**Consultation Response from KC,
Lead Local Flood Authority**

2021/94599 Moorhouse Farm, Moorhouse Lane, Birkenshaw, BD11 2AY

Erection of 6 dwellings and associated works

Date Responded: 14/02/2022

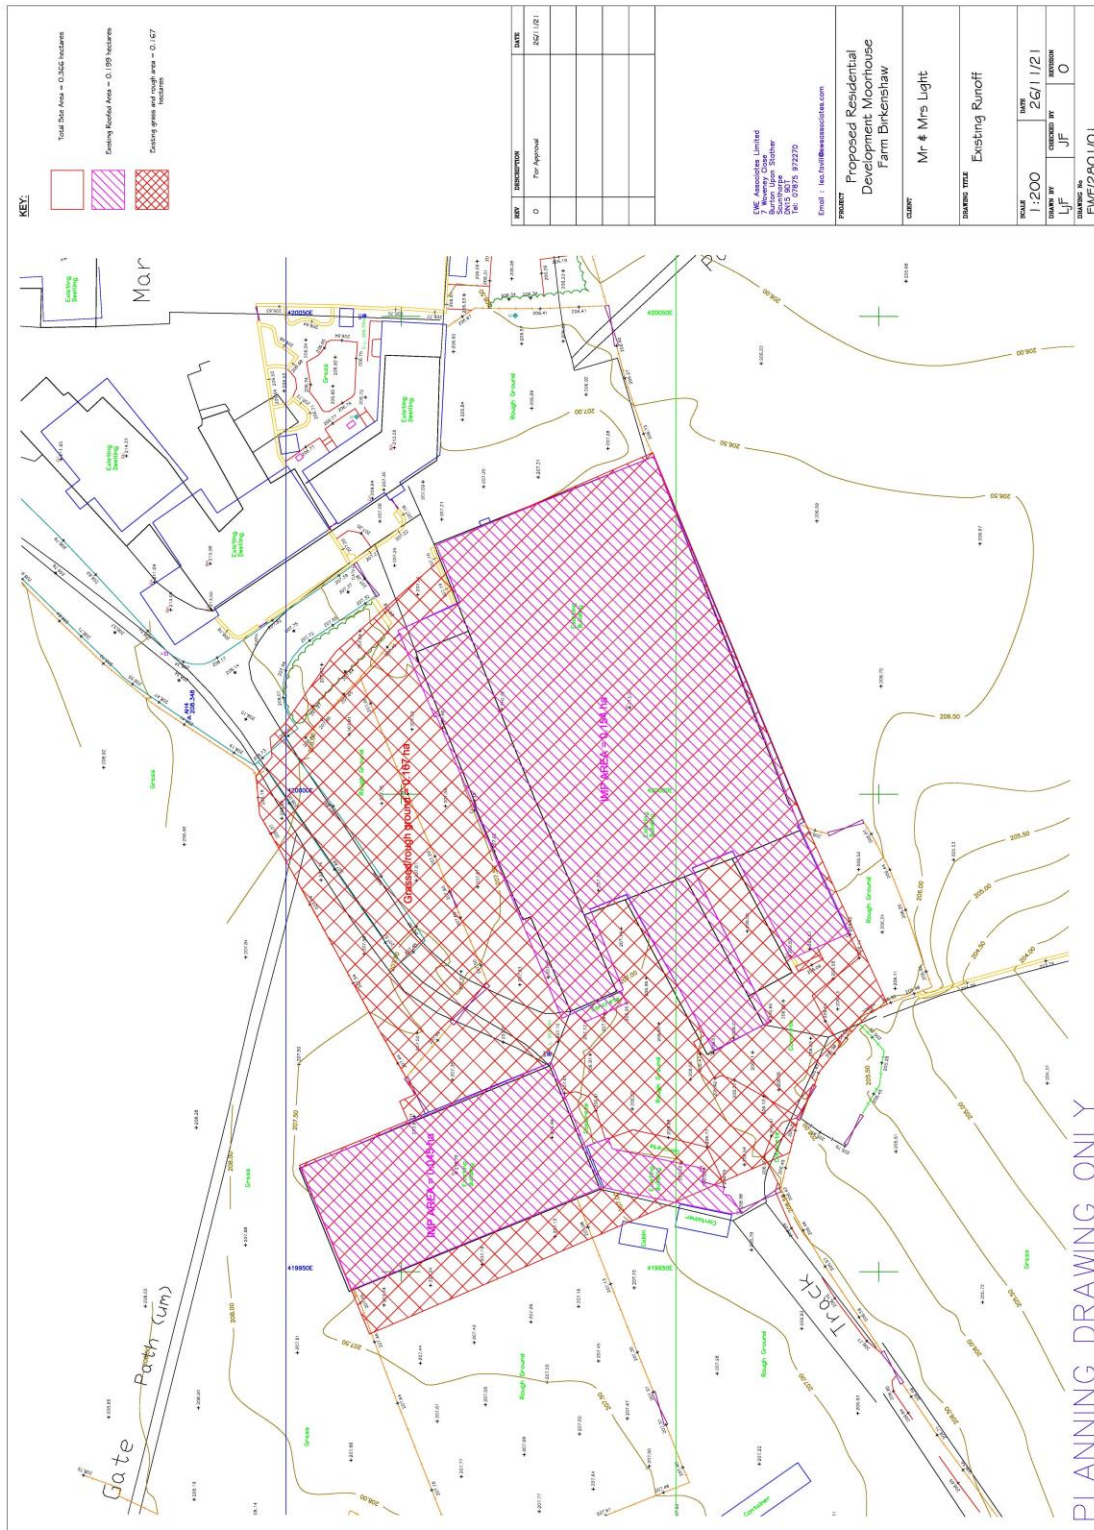
The developer is proposing to discharge attenuated flows into a tributary of Lodge Beck which is an acceptable outfall location for the LLFA. However, the proposed discharge rate from the flow control device of 21.6 l/s is not acceptable. The allowable discharge rate should be 30% less than the surface water run-off from the existing buildings that are to be demolished – i.e. using the existing roof area of 0.199 ha (as stated on drawing EWE/2801/01) and applying a 50mm/hr rainfall intensity. The LLFA calculate this figure to be 27.66 (existing run-off) x 0.7 = **19.4 l/s**. The volume of the attenuation storage should be re-calculated using this lower figure to ensure that rainfall up to the 1 in 100 year event (plus 30% climate change) is retained on site without causing flooding to the curtilage of existing or proposed buildings.

The attenuation tank shall have a low flow channel/perforated pipe laid at a self-cleansing gradient crossing through/under the tank in a straight line from the inlet to the outlet MHs as indicated in the SuDS Guidance (CIRIA C753) which is the national recommended design of cellular storage tanks, Figures 21.4, 21.6 to 21.7. This is to minimise the risk of silt build-up within the geocellular tank which would be difficult to remove.
